KITITAS COUNTY

DEPARTMENT OF PUBLIC WORKS

MEMORANDUM

TO: All Staff
FROM: Zachery Peebles, Engineering Technician I
DATE: April 27, 2021
SUBJECT: BL-21-00006 Mundy

PART OF SECTIONS 27, 28, 33 & 34,
TOWNSHIP 20 NORTH, RANGE 16 EAST, W.M.

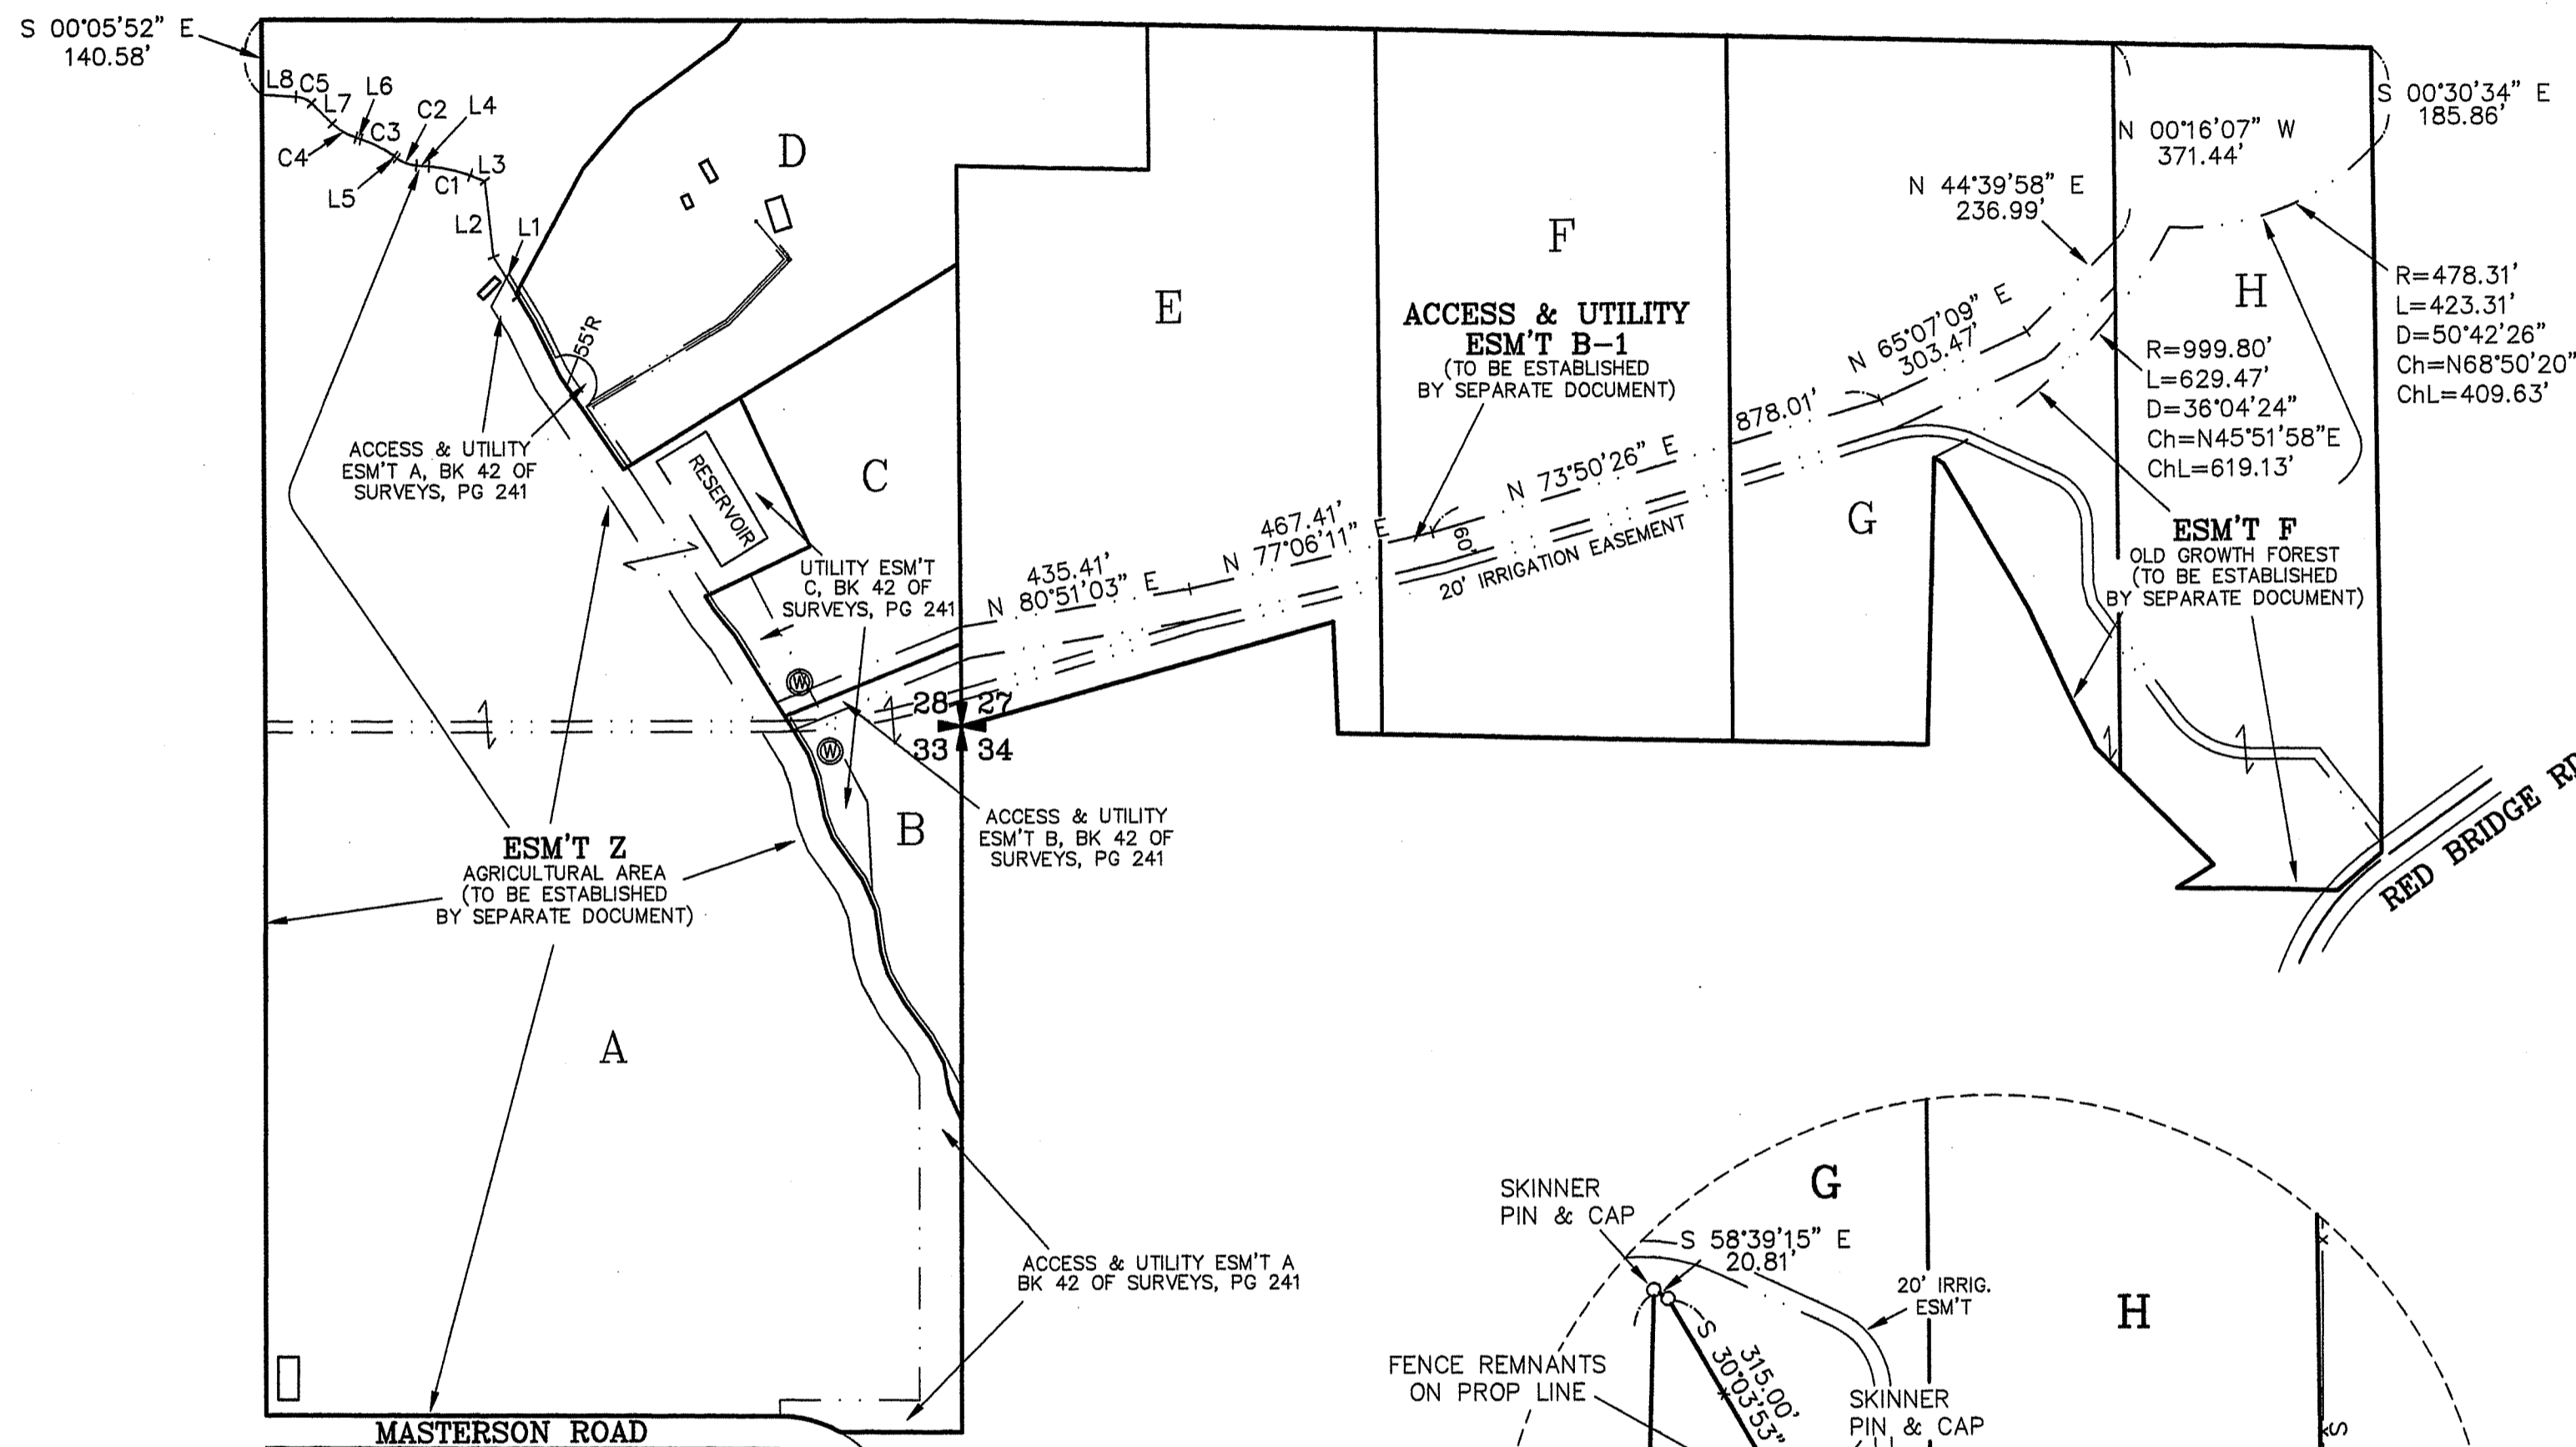
1. A revised legal description that describes the final configuration of the subject property shall be required.
2. A survey map is required for review. Any comments on the survey map will be reserved for final.
3. Please show all access easements on the face of the BLA.
4. Please provide a recorded copy of the proposed 60' driveway easement.

Proposed

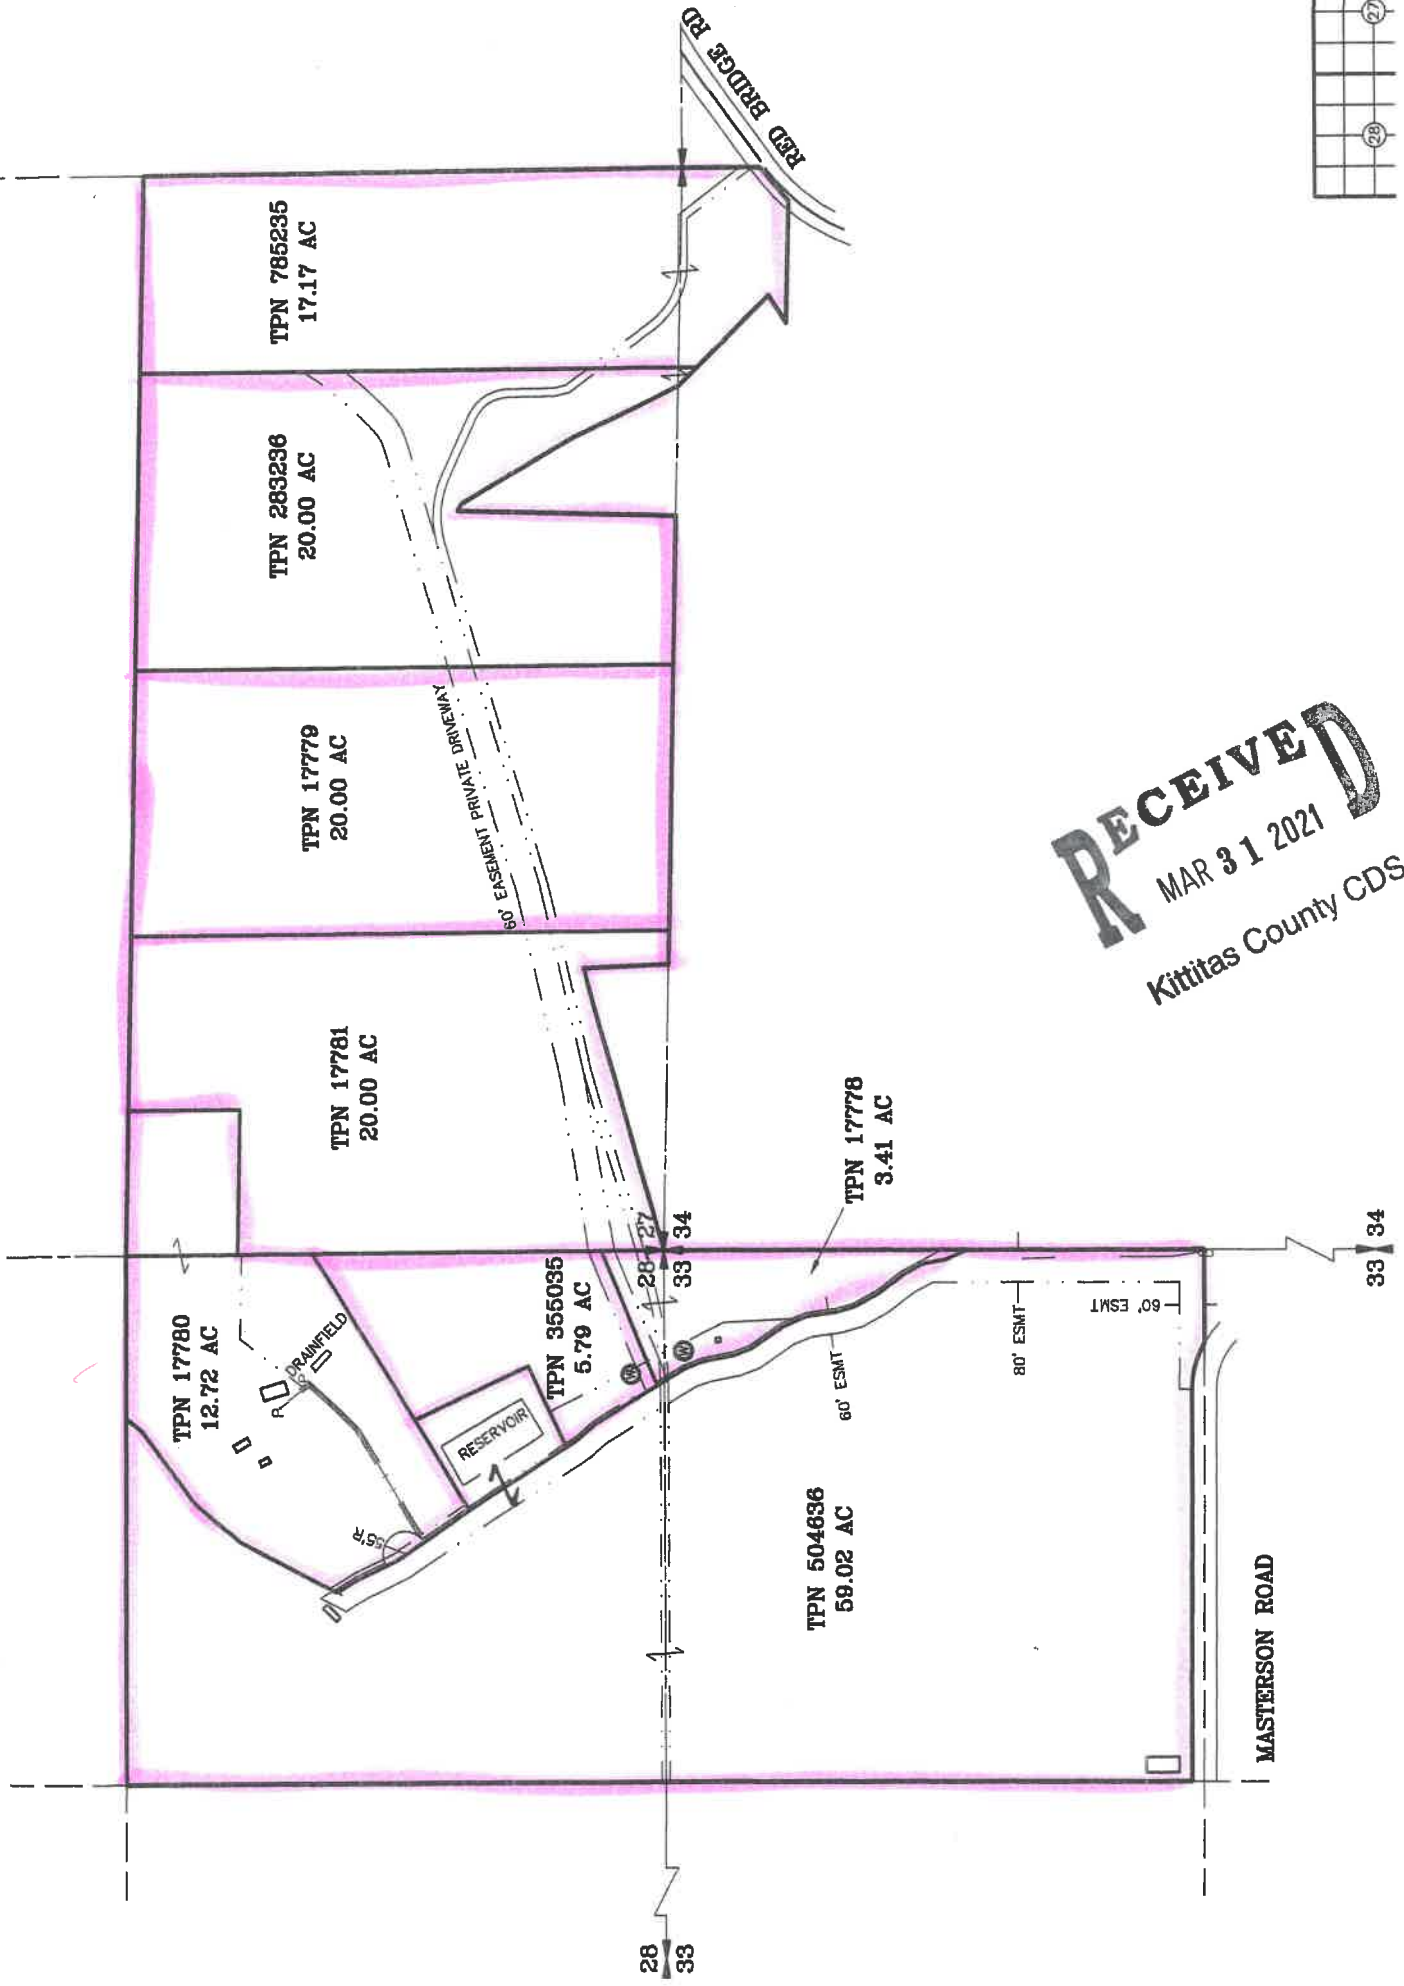
- a. An approved access permit shall be required from the Kittitas County Department of Public Works prior to creating any new driveway access or changing an existing access.
- b. The proposed 60' driveway easement does not have adequate room for a private road turnaround. The proposed access can only serve up to four lots as a joint-use driveway.
- c. Maintenance of driveway approaches shall be the responsibility of the owner whose property they serve. The County will not maintain accesses.
- d. Any further subdivision or lots to be served by proposed access may result in further access requirements. See Kittitas County Road Standards.
- e. Evidence of existing access and/or evidence of access to be created should be confirmed prior to sale of property.
- f. Access is not guaranteed to any existing or created parcel on this application.
